From: Carl Moore
Sent: Wednesday, May 30, 2018 9:52 AM
To: 'Andrew Wood' <Andrew.Wood@arun.gov.uk>
Cc: 'Steve Nash' [REDACTED]
Subject: RE: 45 Angmering Lane, East Preston

I refer to our recent correspondence with regard to the current planning application at 45 Angmering Lane in East Preston. I also note the comments that have been made on the planning website from three neighbours.

PROPOSED EAST ELEVATION 1:100

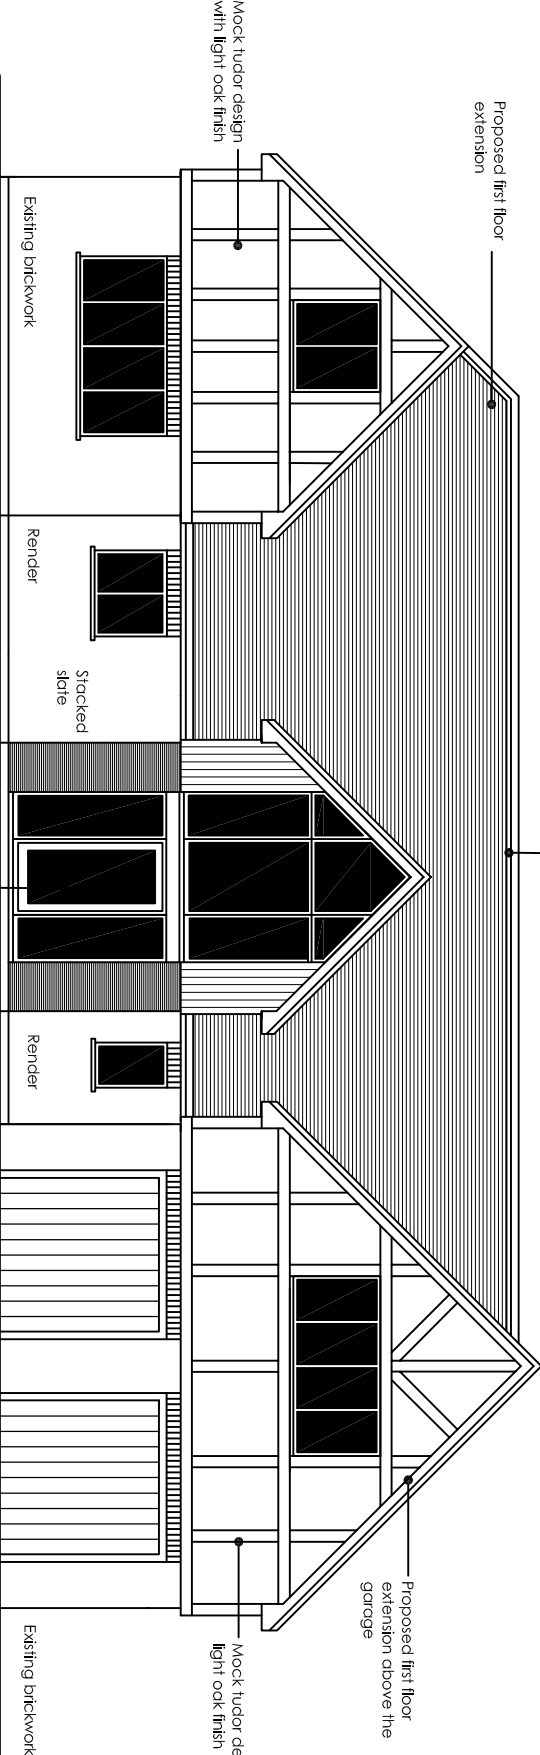
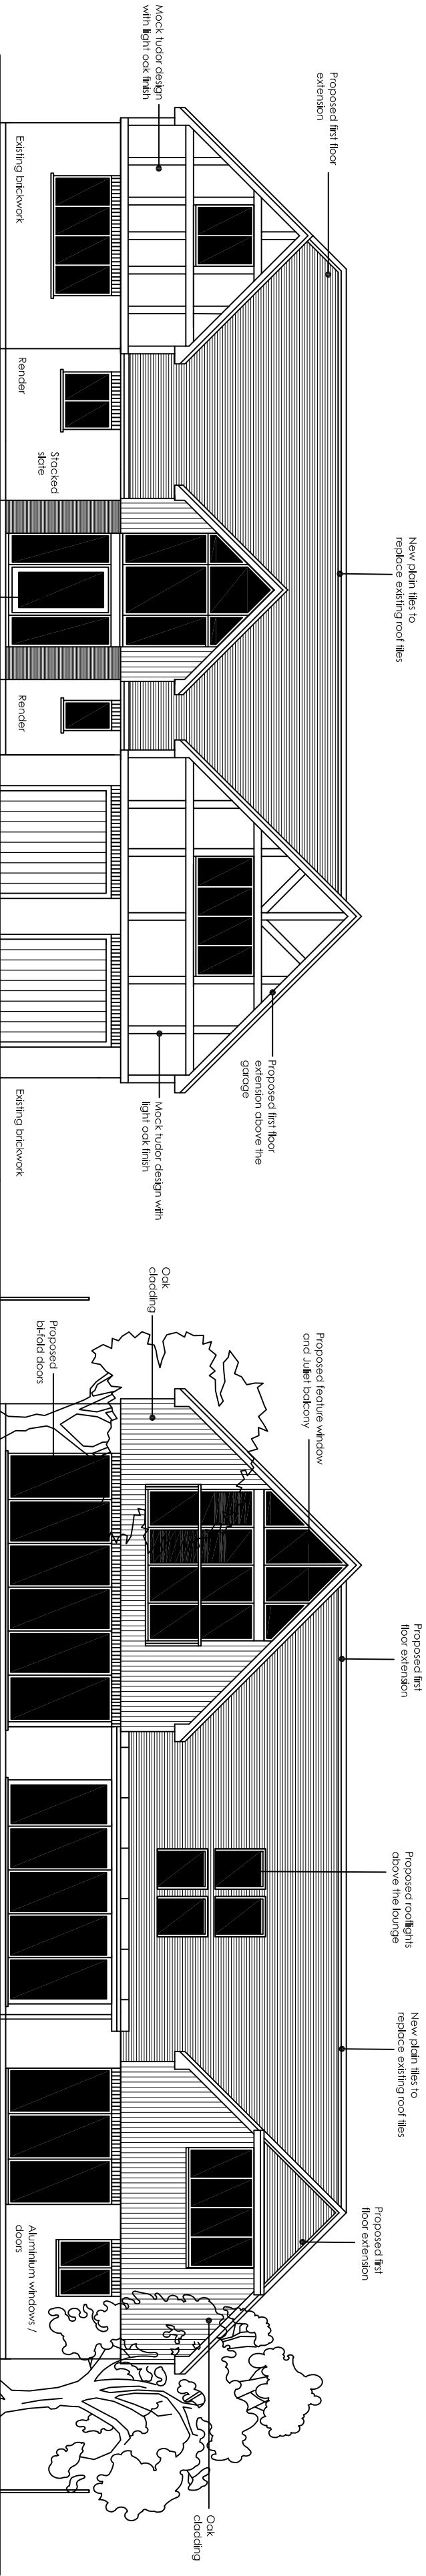
- Mr & Mrs Amos – 43 Angmering Lane – have raised an objection to the Juliet balcony in the master bedroom. As we have previously discussed, the Juliet balcony has been removed from the master bedroom and therefore I have attached a copy of the amended plans that confirm this point. If you should require any further details then please let me know.

As requested I have removed the Juliet balcony from the master bedroom and I have attached a copy of the revised plans for your attention. I am aware that you suggested swapping the master bedroom to the southern side but please note the first floor extension is being built from

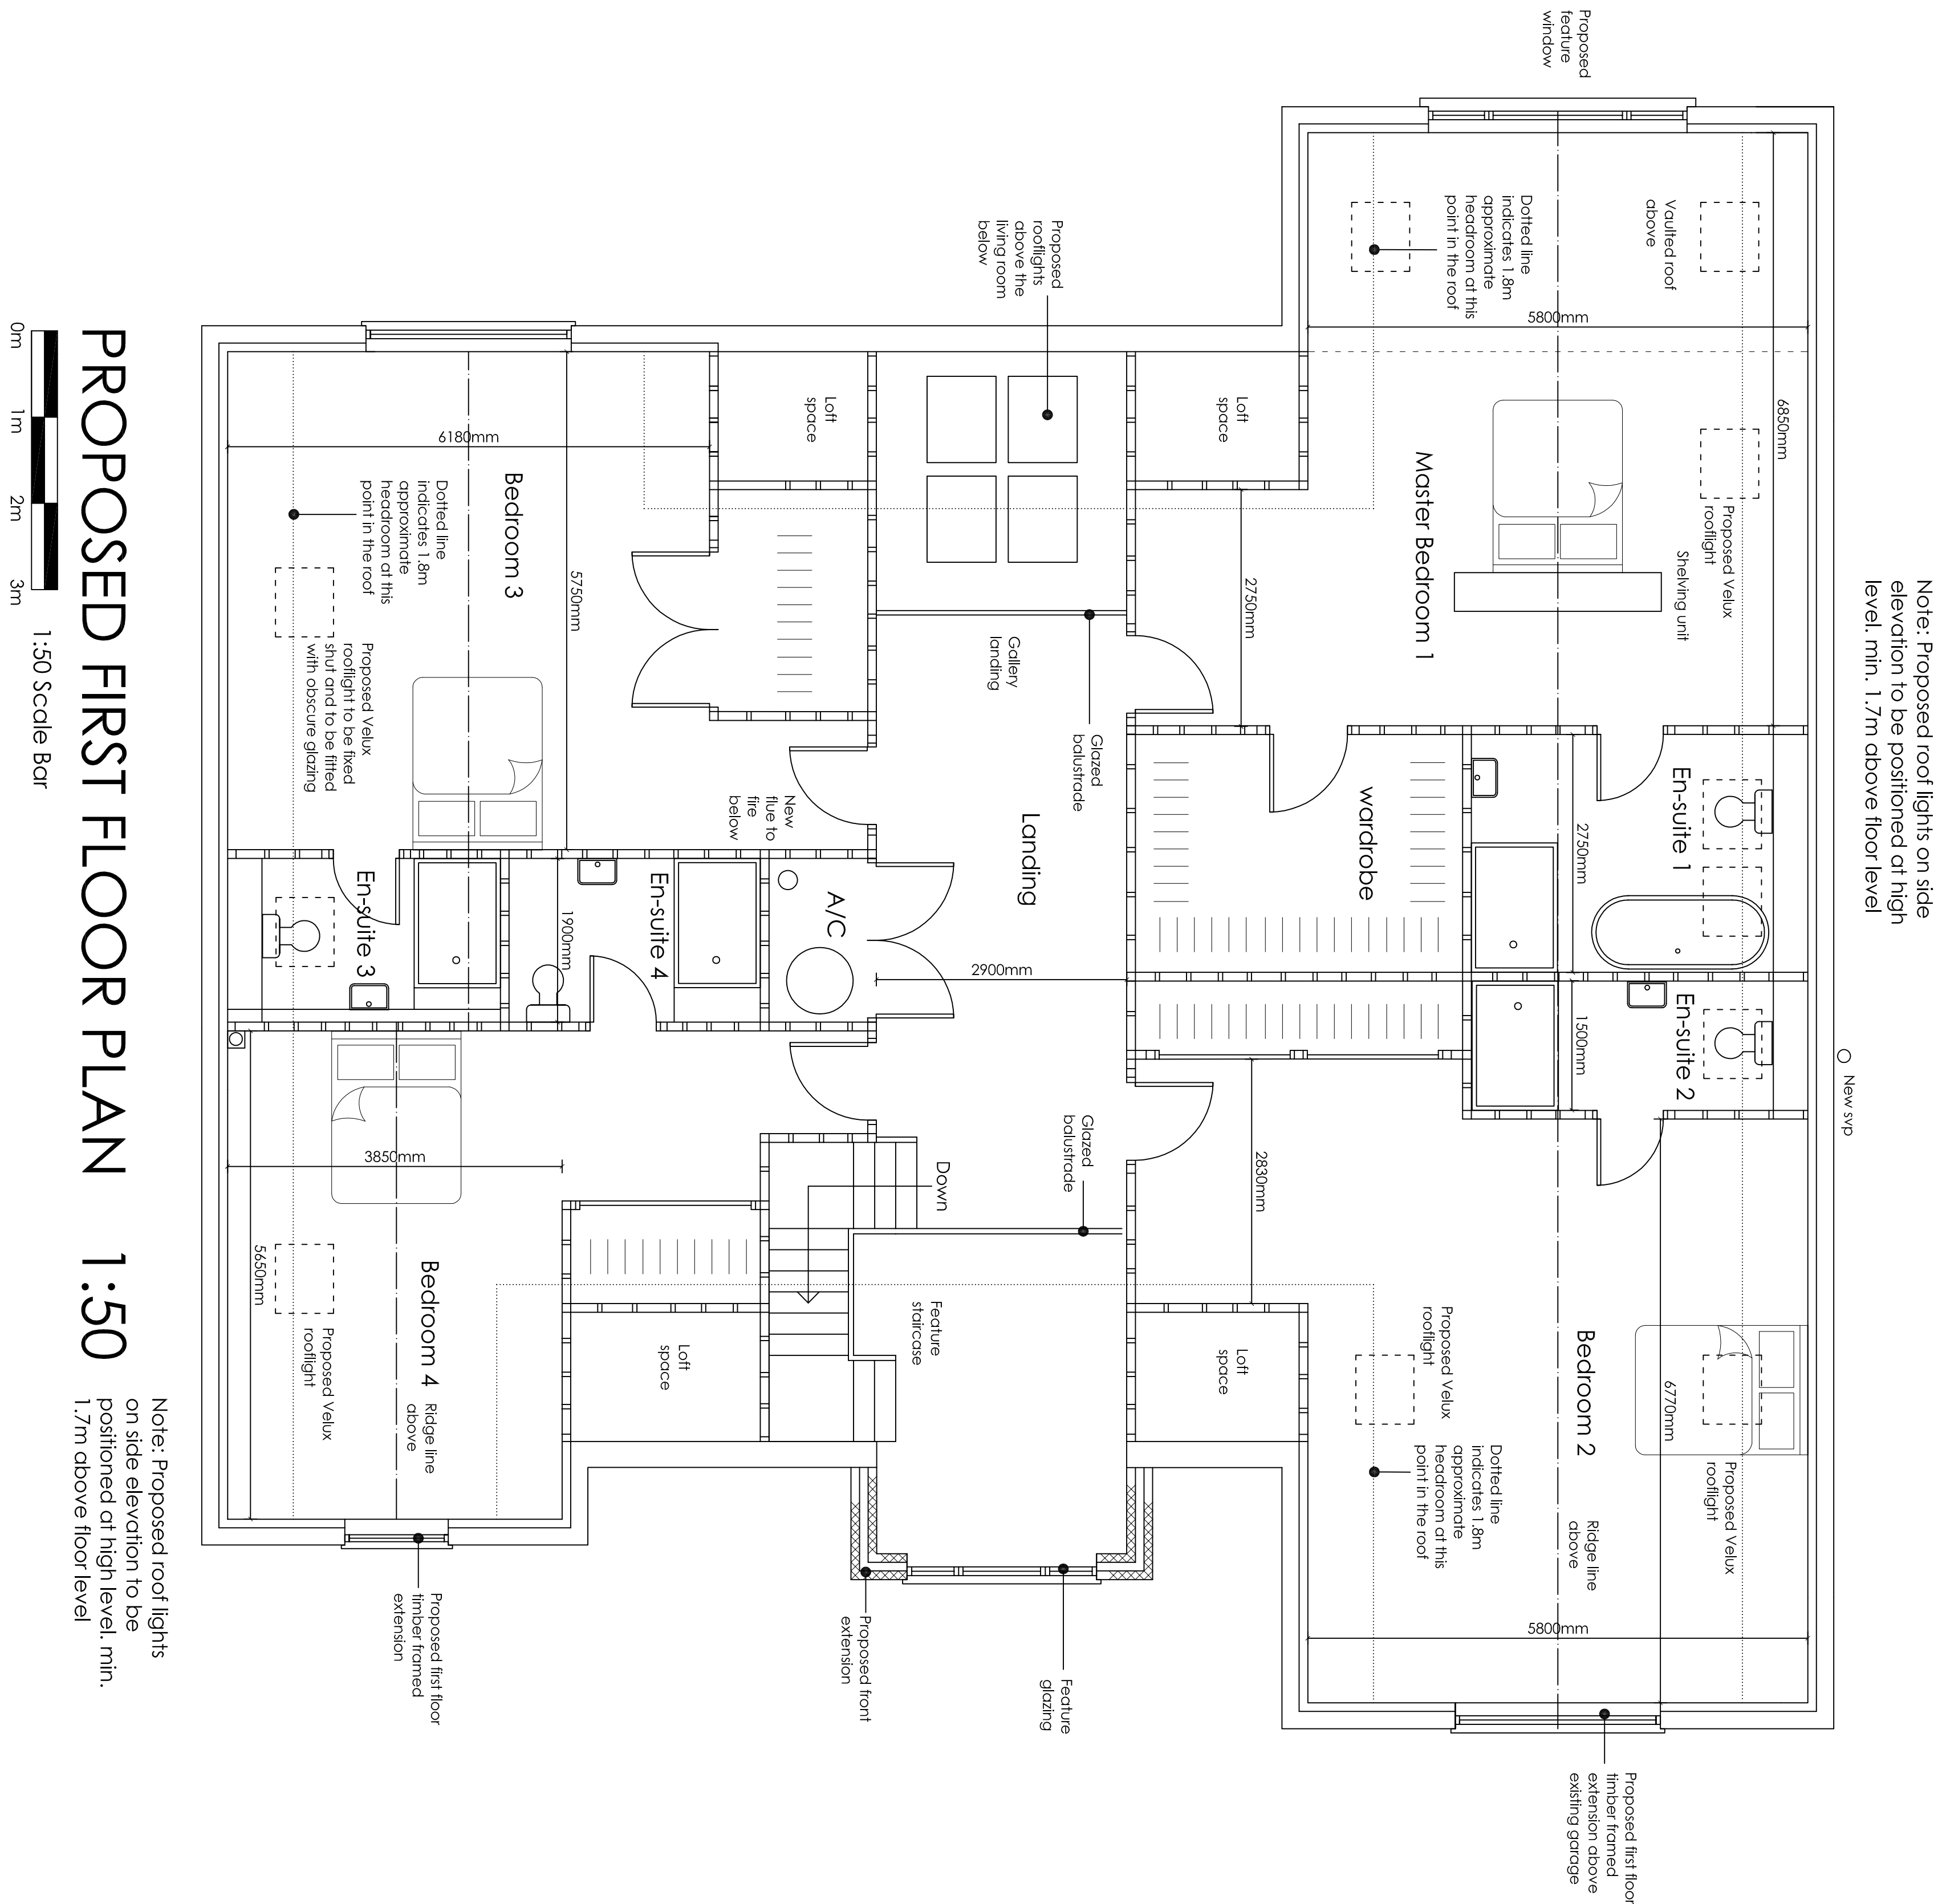
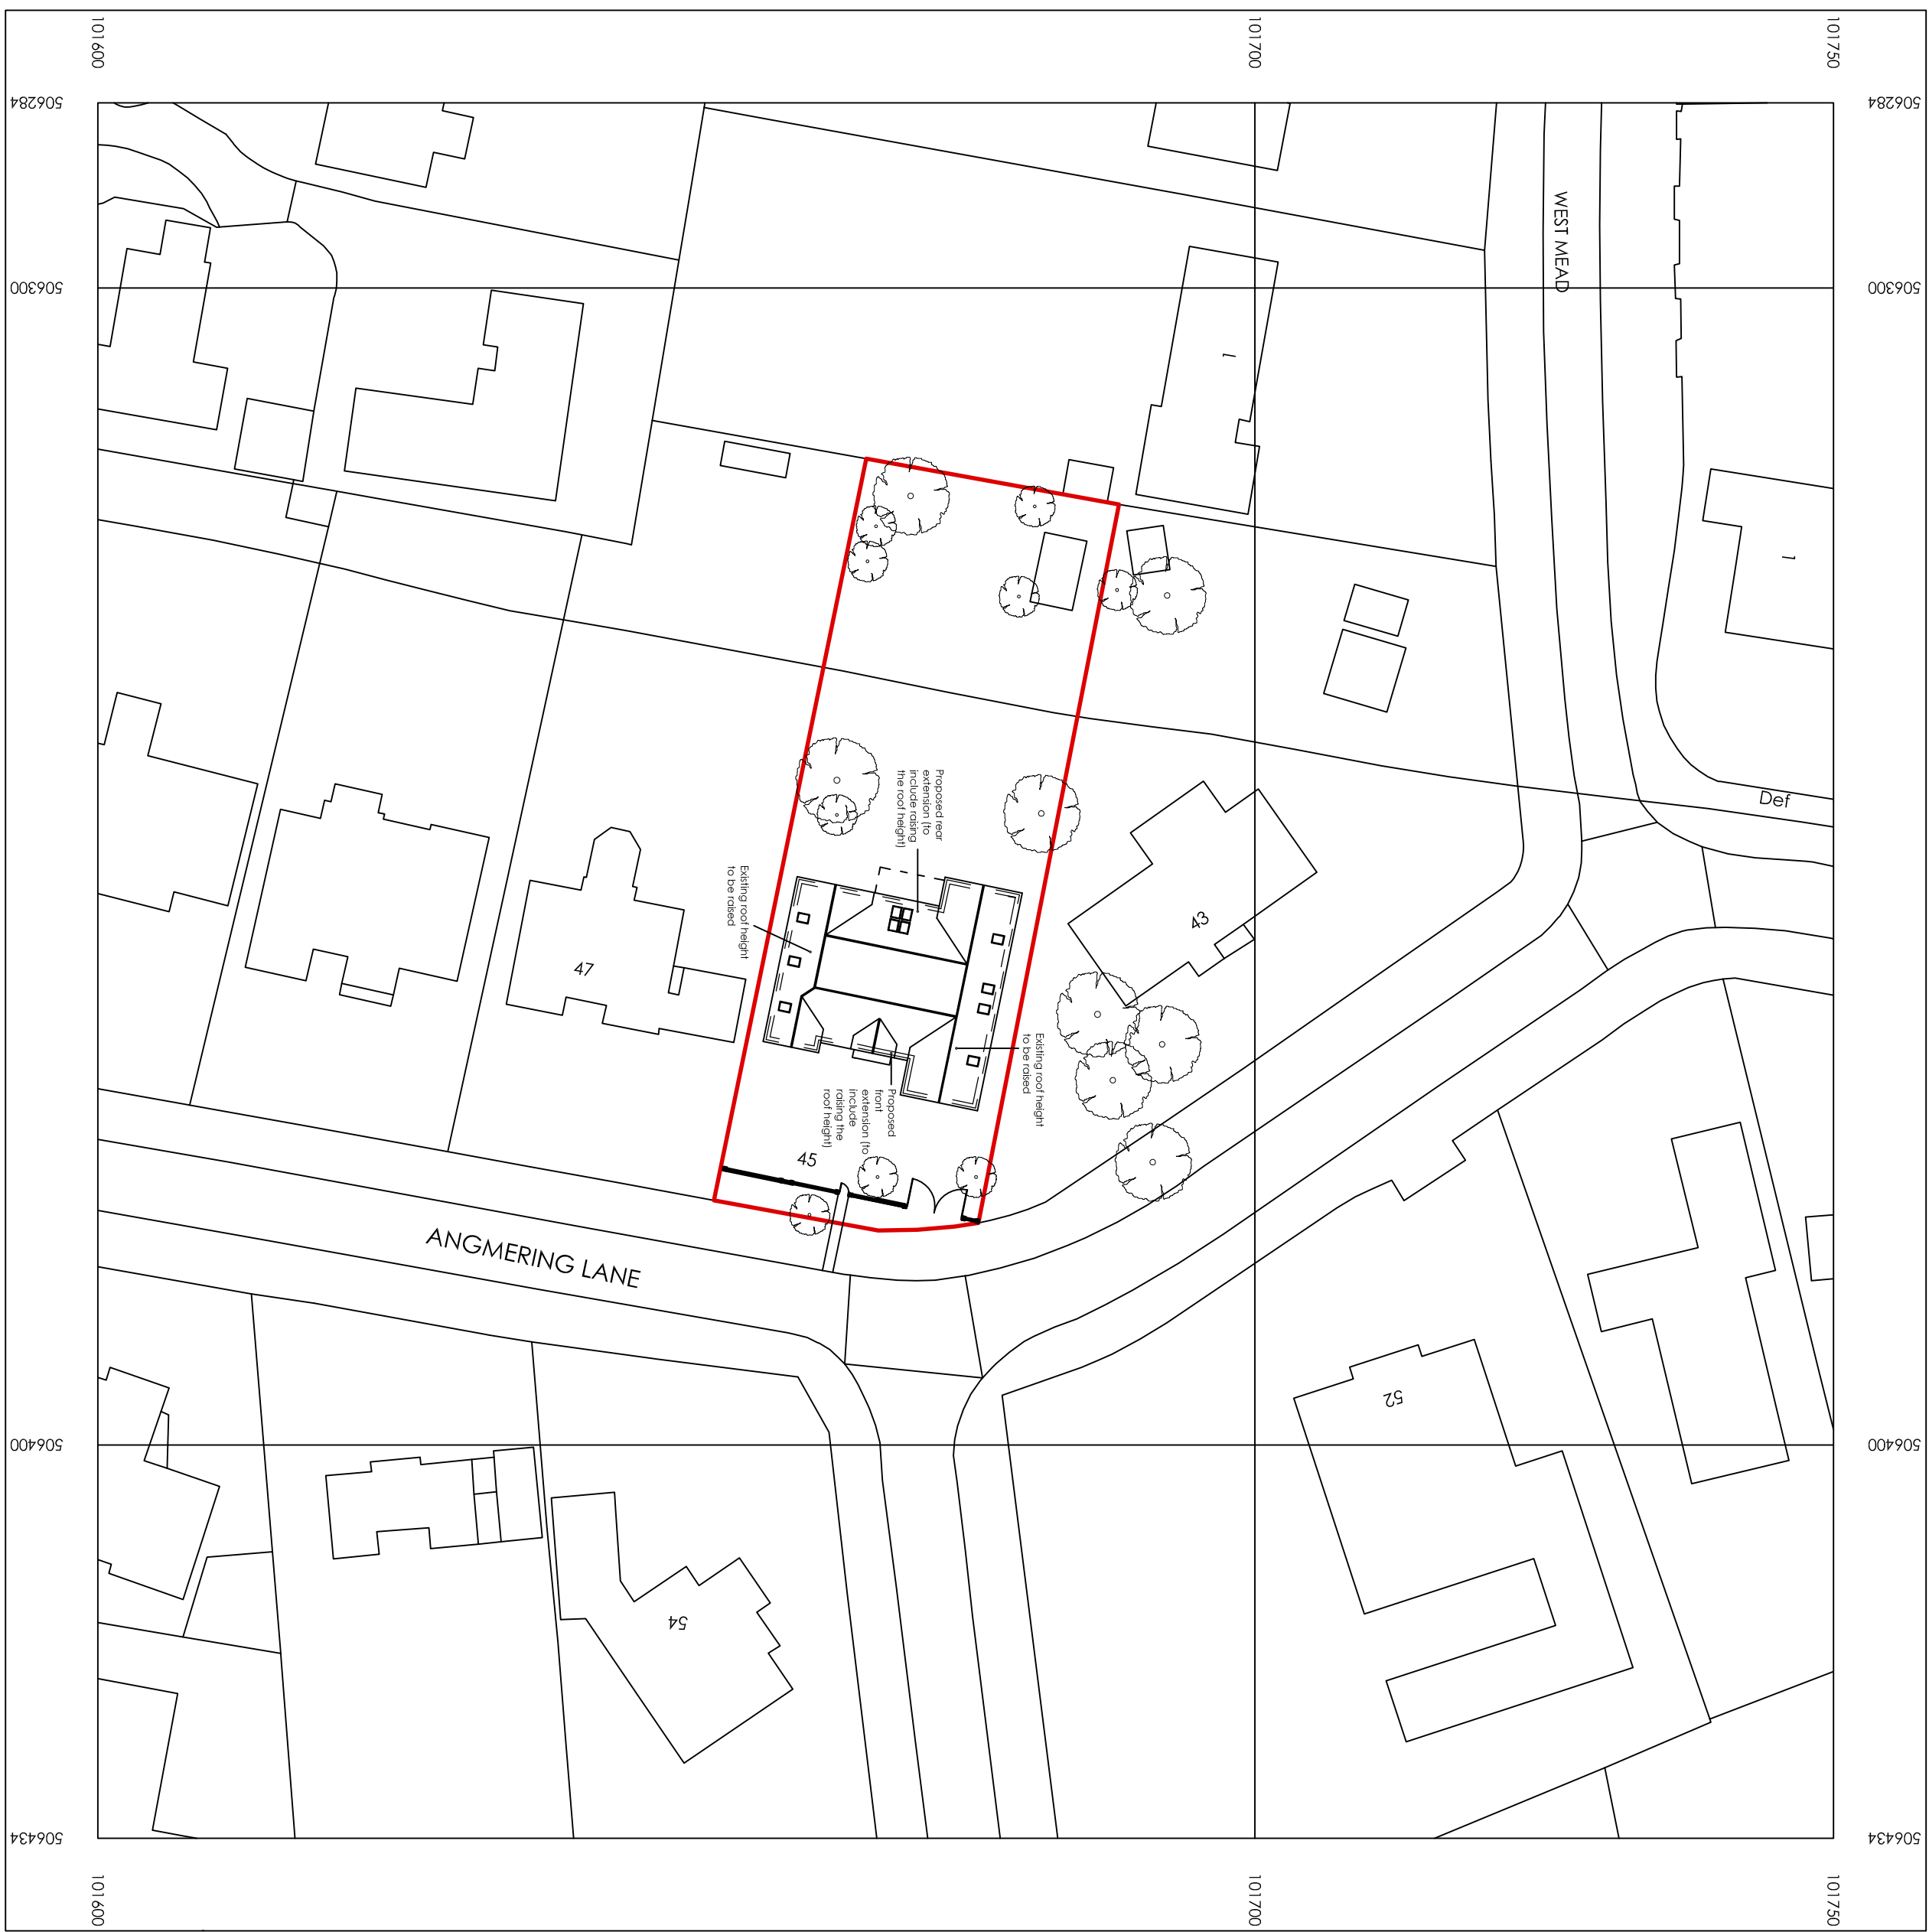
- Mr S. James – 47 Angmering Lane – No objection, however Mr James has agreed with the client that the rooflight located on the south west corner shall be fixed shut and is to have obscure glazing. I can confirm that we agree to this amendment and should be grateful if you could provide a planning condition on this point. I have attached a revised first floor plan which includes this amendment. Please also note that all rooflights on the side elevation are to be positioned 1.7m above floor level to prevent any direct overlooking.
